**Application: SSI 7485**

I write regarding the proposed modification to M4-M5 Link, Mod 2 The Crescent overpass and changes to pedestrian infrastructure in North Annandale, Rozelle and Rozelle Bay Foreshore area.

Figure 4-2 Pedestrian and cyclist bridge infrastructure options

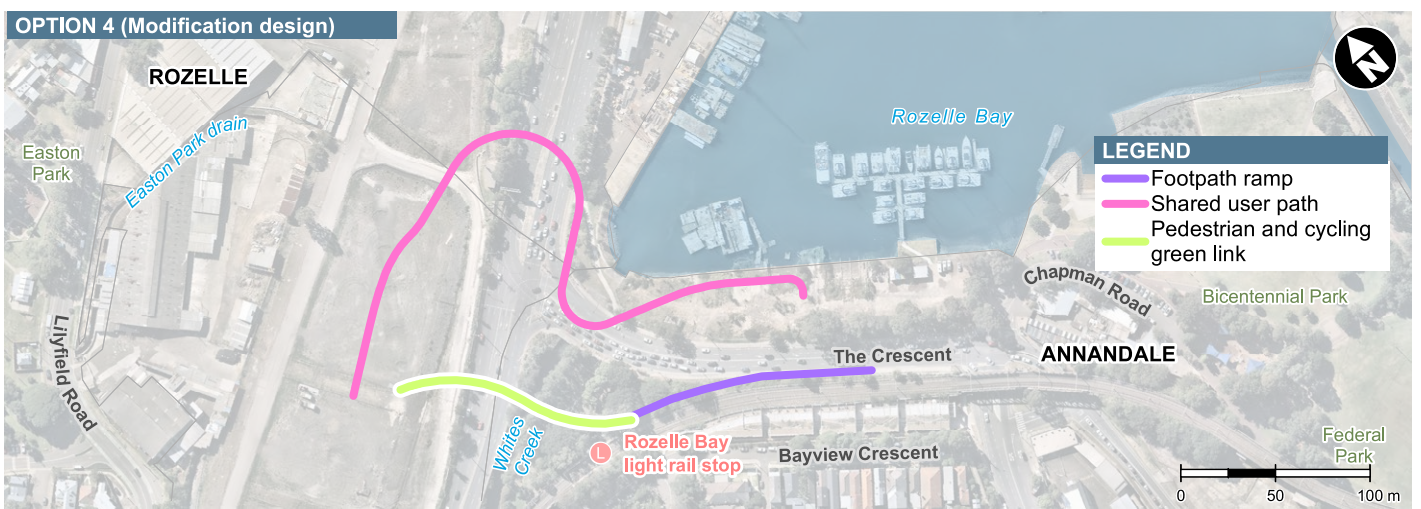
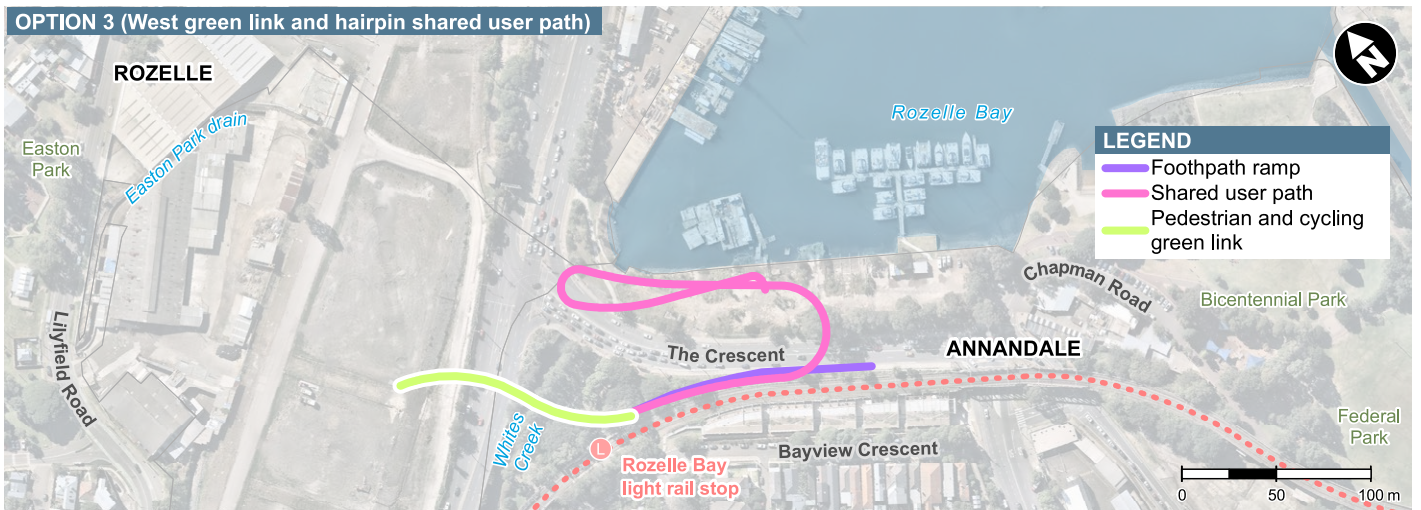
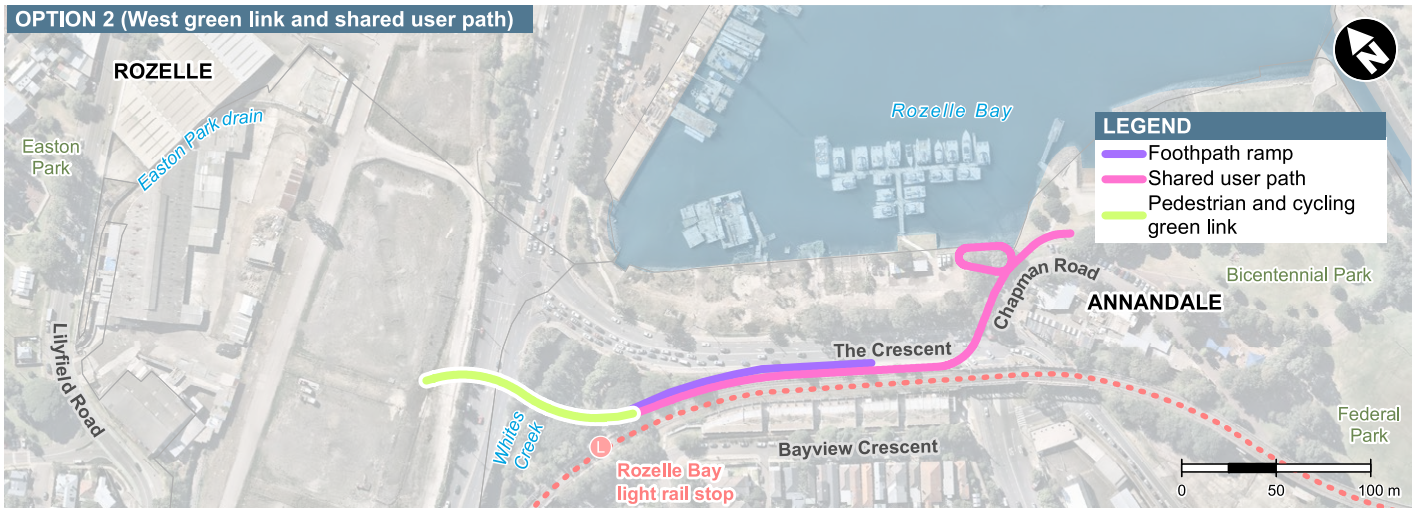
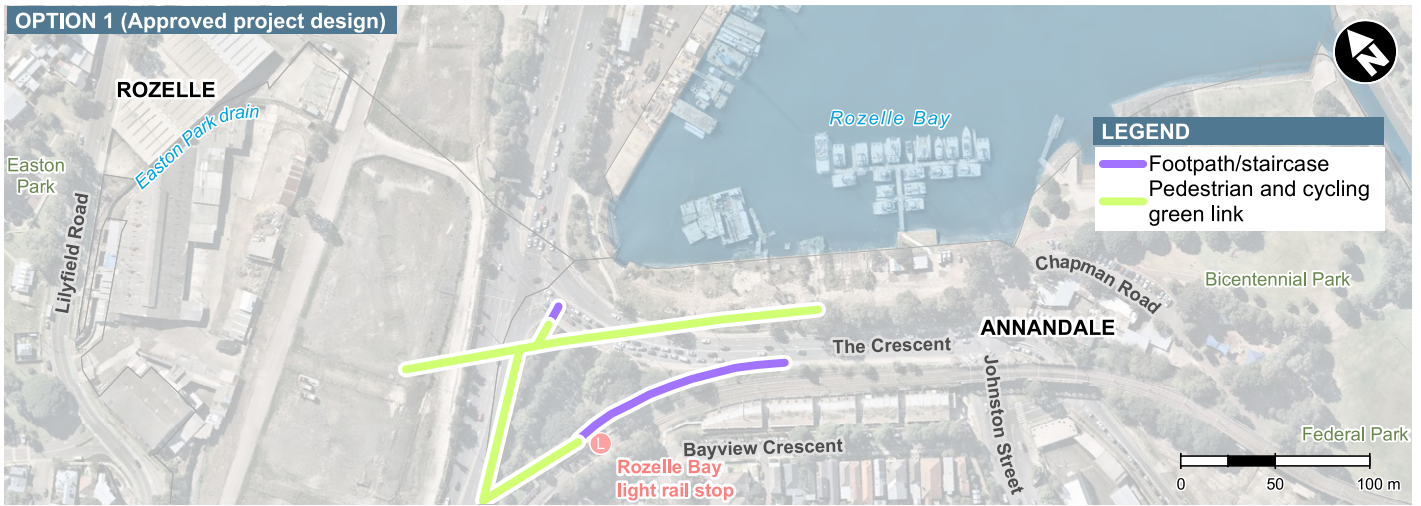
I request RMS work with the community to explore alternate design options to the proposed new car overpass design and the changed pedestrian and cyclist links. I am seeking the reinstatement of the safe, direct access from the approved EIS GreenLink to create a continuous green open space connection from the Rozelle Rail yards and Annandale to the foreshore. The GreenLink was more than just a walk way - it put people central to the design, maximising safety, and providing much needed accessible open space for the community now and into the future Bays Precinct design.

- The significantly reduced safety and increased risk for pedestrians and cyclists with removed access over The Crescent to Bicentennial Park and the increased traffic along Johnson Street.
- Being required to cross five sets of pedestrian lights at The Crescent as my option to reach the foreshore from Annandale or from Rozelle Bay light rail stop.
- Removal of direct active links to the foreshore, cutting the community off from the area and the proposed revitalisation of the entire Bays Precinct, including linking the Light Rail and Bus stops to a Ferry wharf and Metro station.
- Urban and landscape design that is being built before a finalised Masterplan for the area.
- Traffic changes that limit movements around the suburb and create further congestion in the local streets of Annandale, Forest Lodge, Glebe, Lilyfield and Rozelle with no planning to deal with these.

- Reinststate the GreenLink connecting communities and green open space from Rozelle to Bicentennial Park
- Relocate and design pedestrian and cyclist connections that are continuous, safe and direct.
- Design the modification infrastructure and active links in response to the character of the suburbs, the location of the foreshore and it's potential future development.
- Provide pedestrian and cyclist paths that maximise people safety and do not force them onto busier streets, unsafe concrete plazas and caged walkways.
- Integrate active and direct connections to all active transport – including the future Metro West and Foreshore Ferry Wharf
